Re Planning Application 2024/90421 31 Crosland Edge, Meltham HD9 5RS.

Further to the above planning application, please record an objection to the proposal on the following basis:

Drawing Title_
AS PROPOSED_ SITE SECTIONS / CONTEXT ELEVATIONS

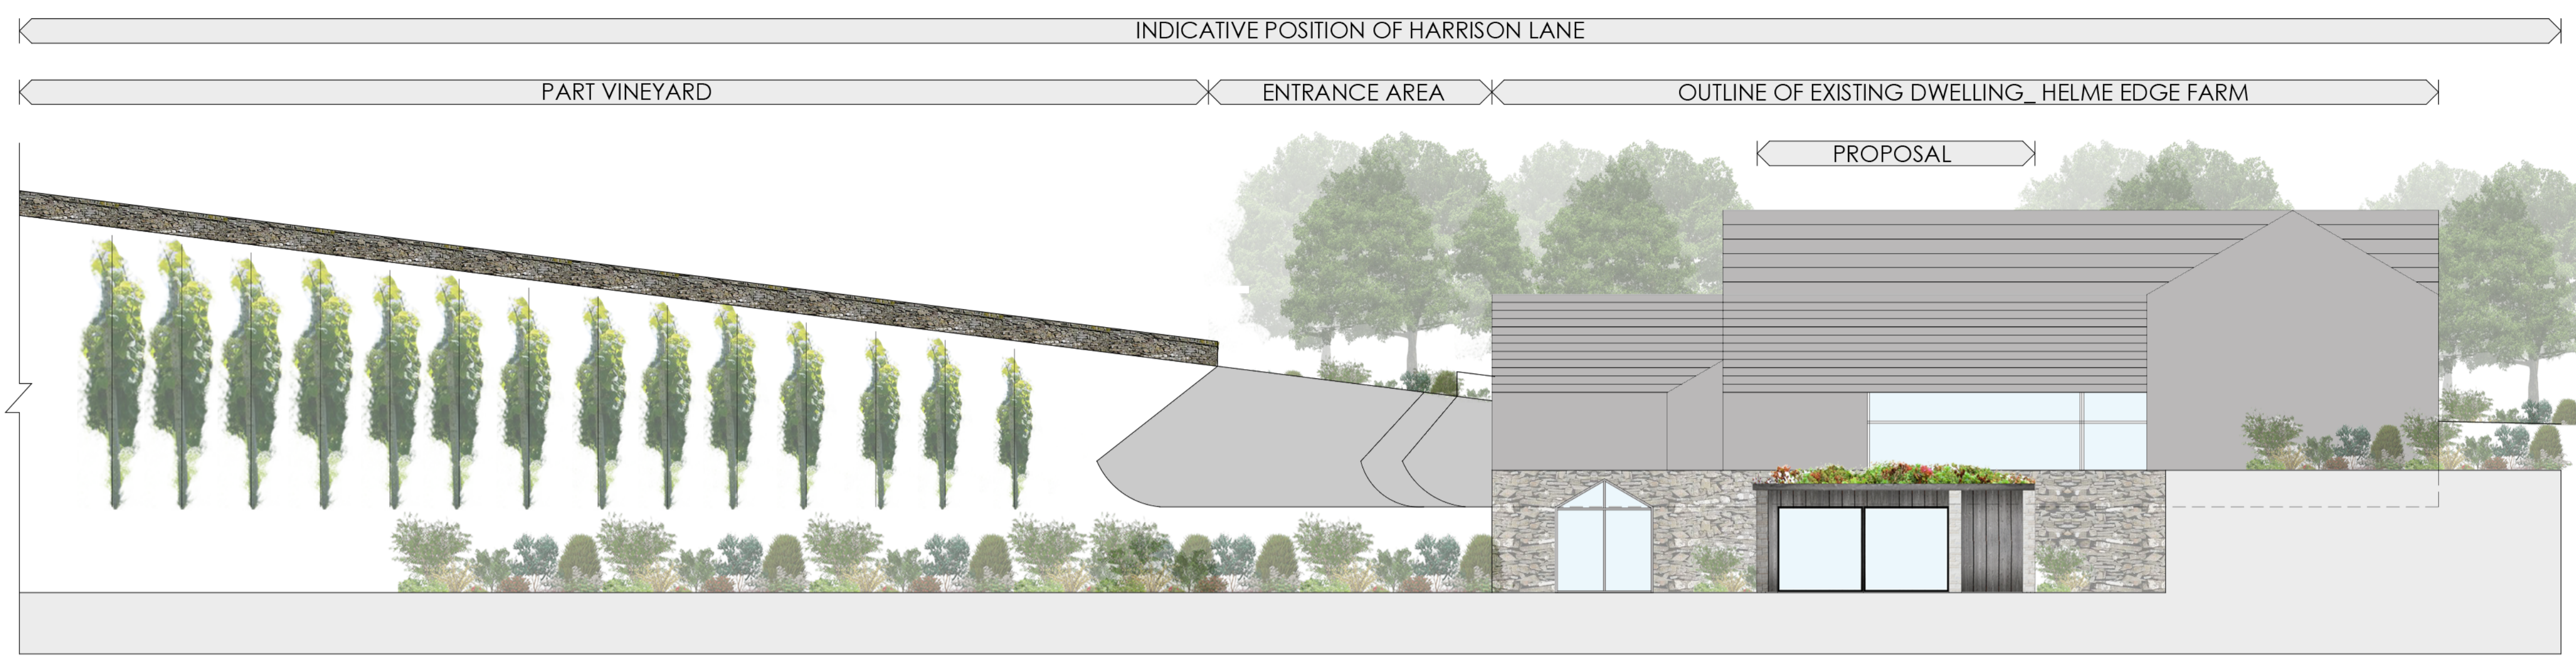
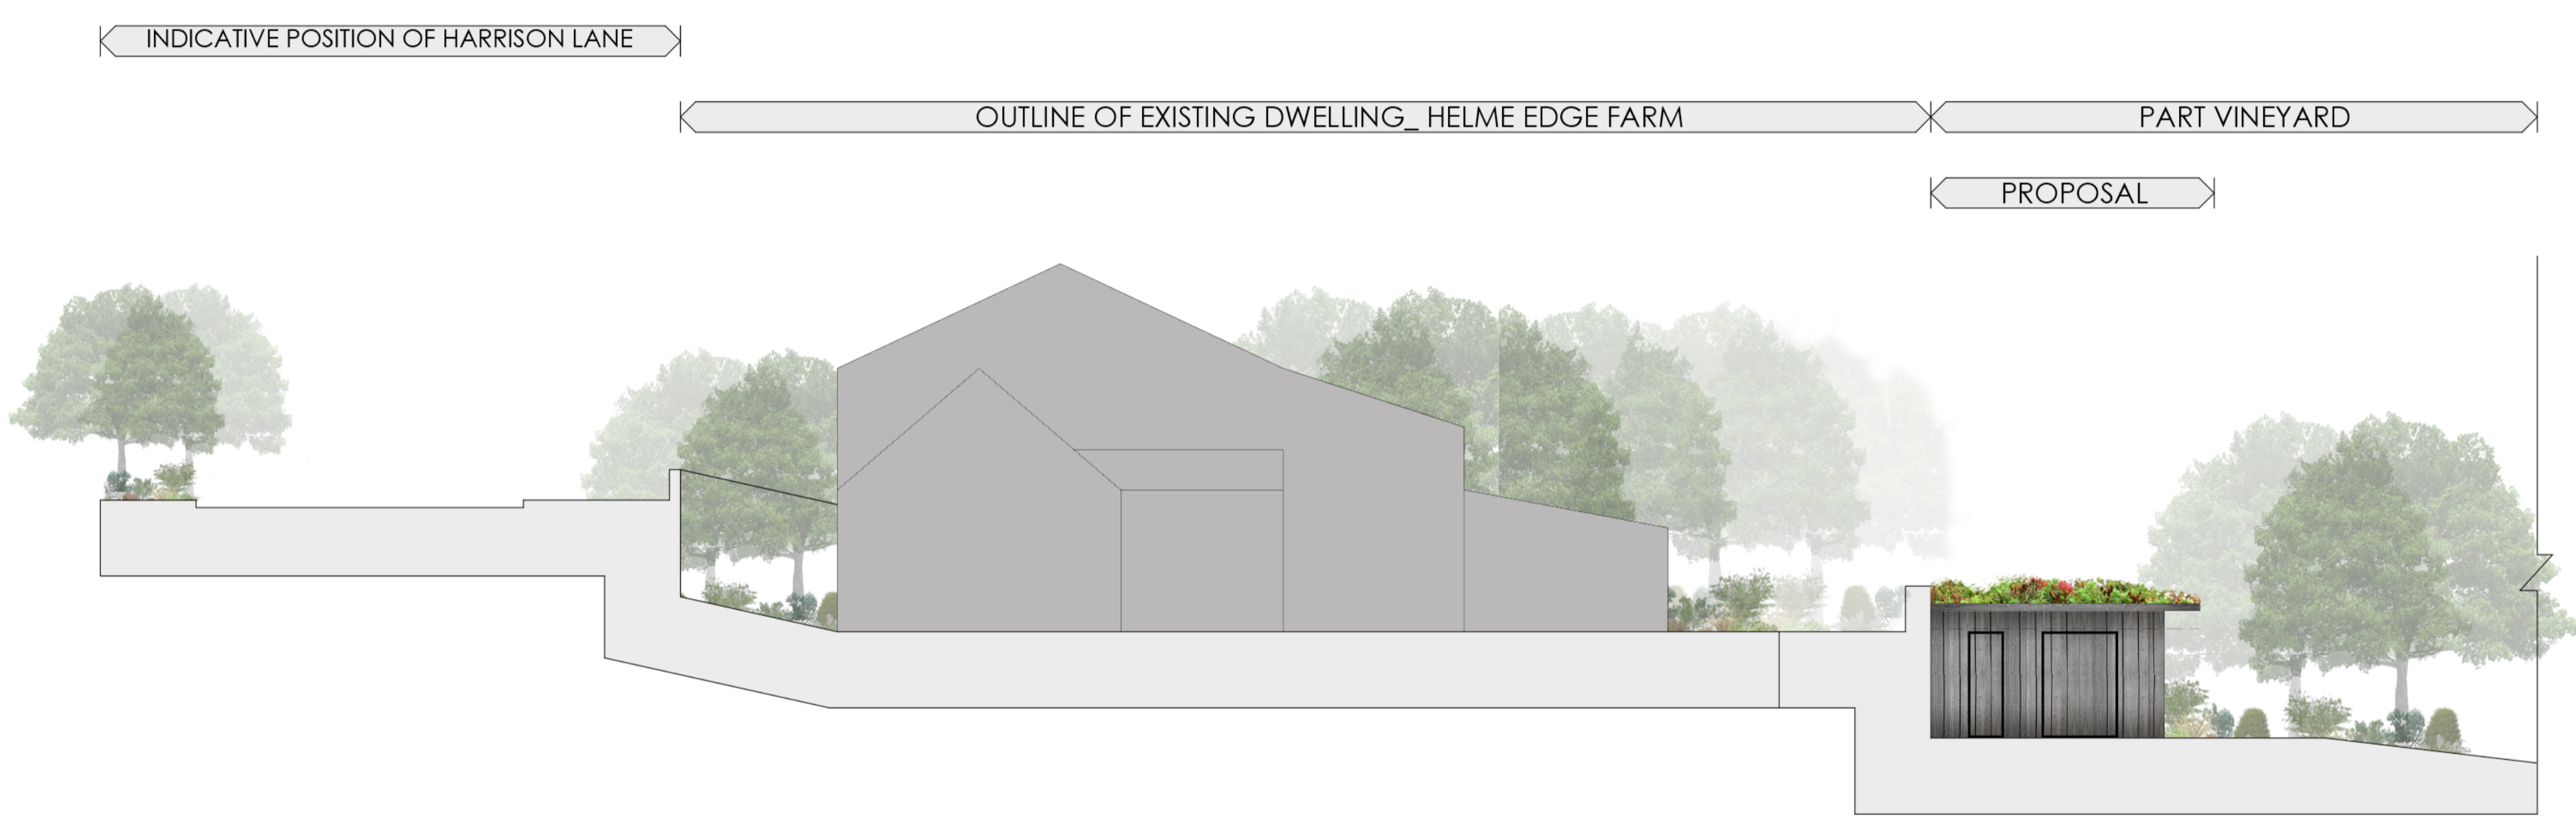
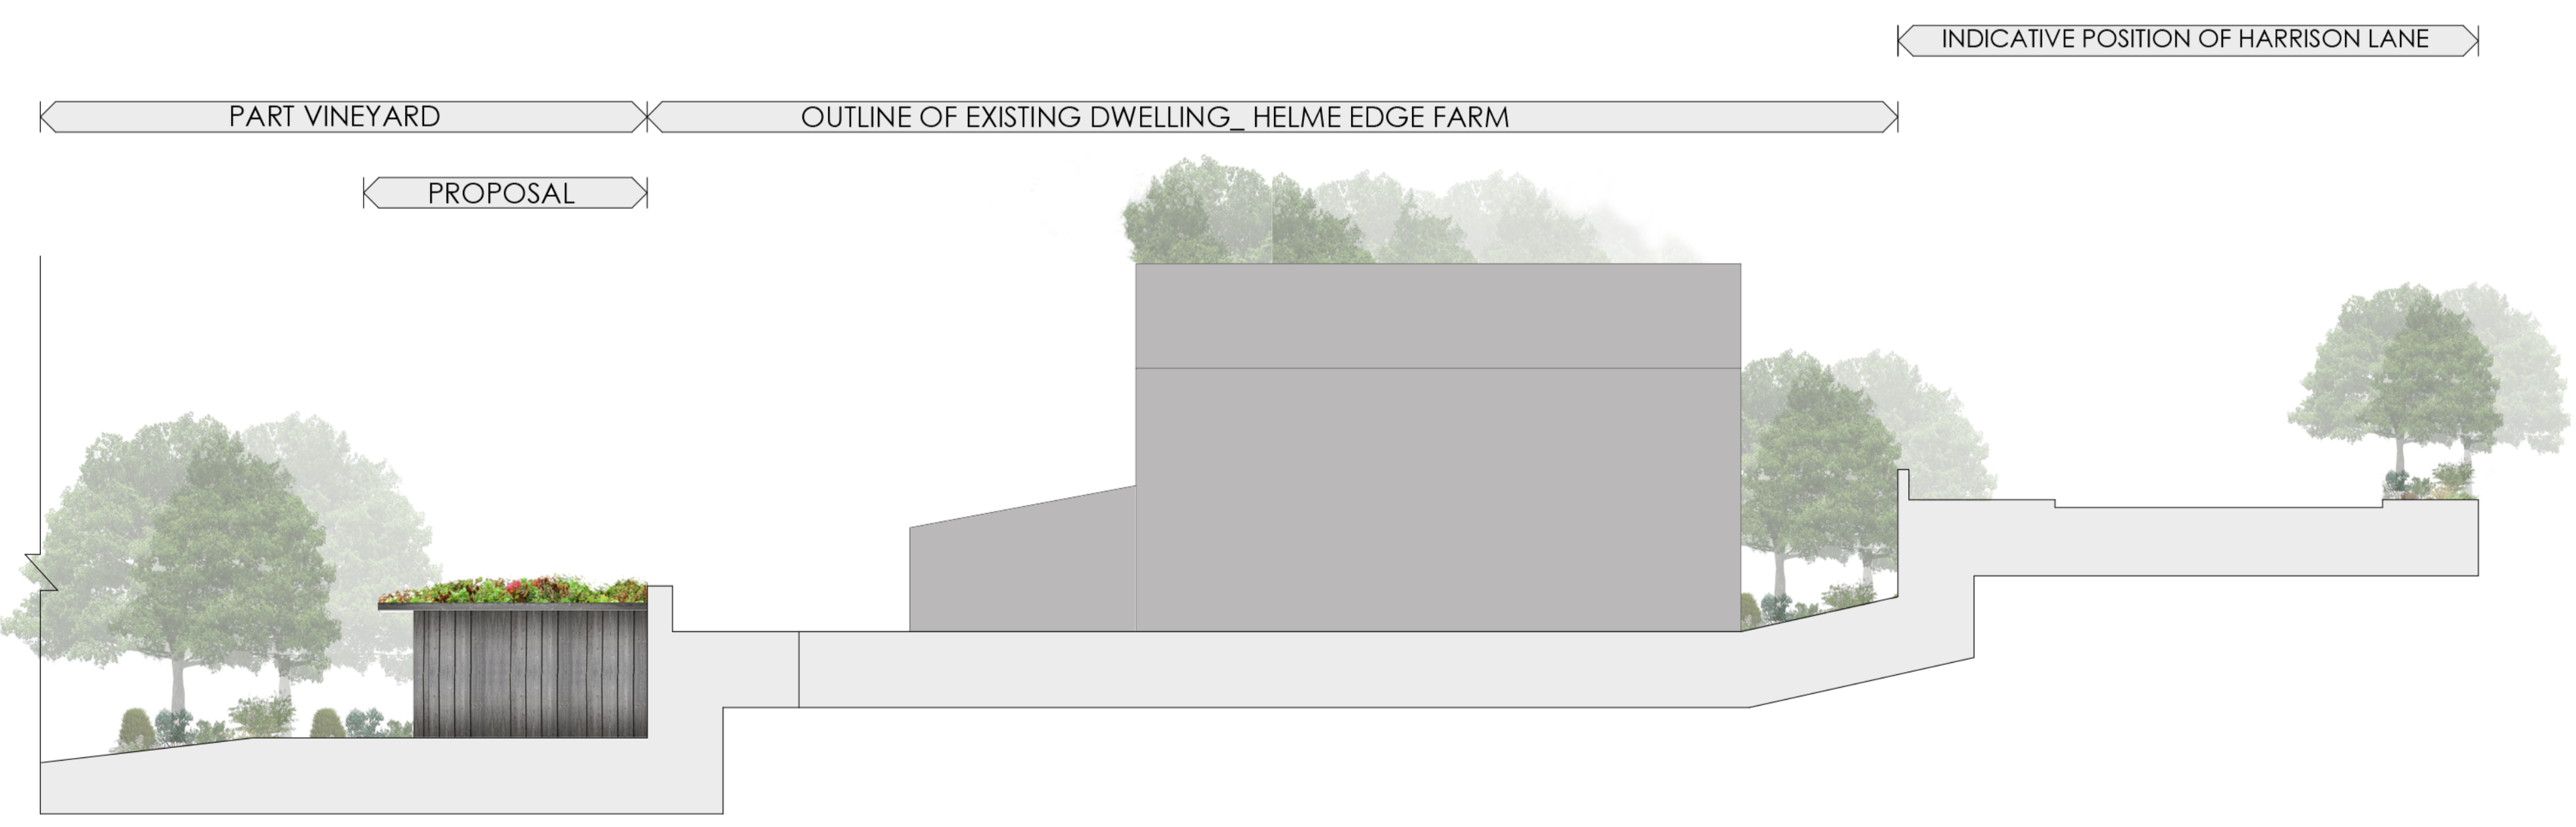
- The submission makes much of the development not visible to the host and protecting its privacy. However, it will be visible to neighbours (look at the site photographs) and anyone looking across to the prominent hillside where it and the car parking will also be seen. The size and location are inappropriate for its primary use, the consumption of alcohol.

- The sketches provided do not reflect the actual site; neighbouring properties are closer than suggested. They show extensive foliage where none exists; where it does, it has tripled in size and scope. These give the wrong impression of the site.
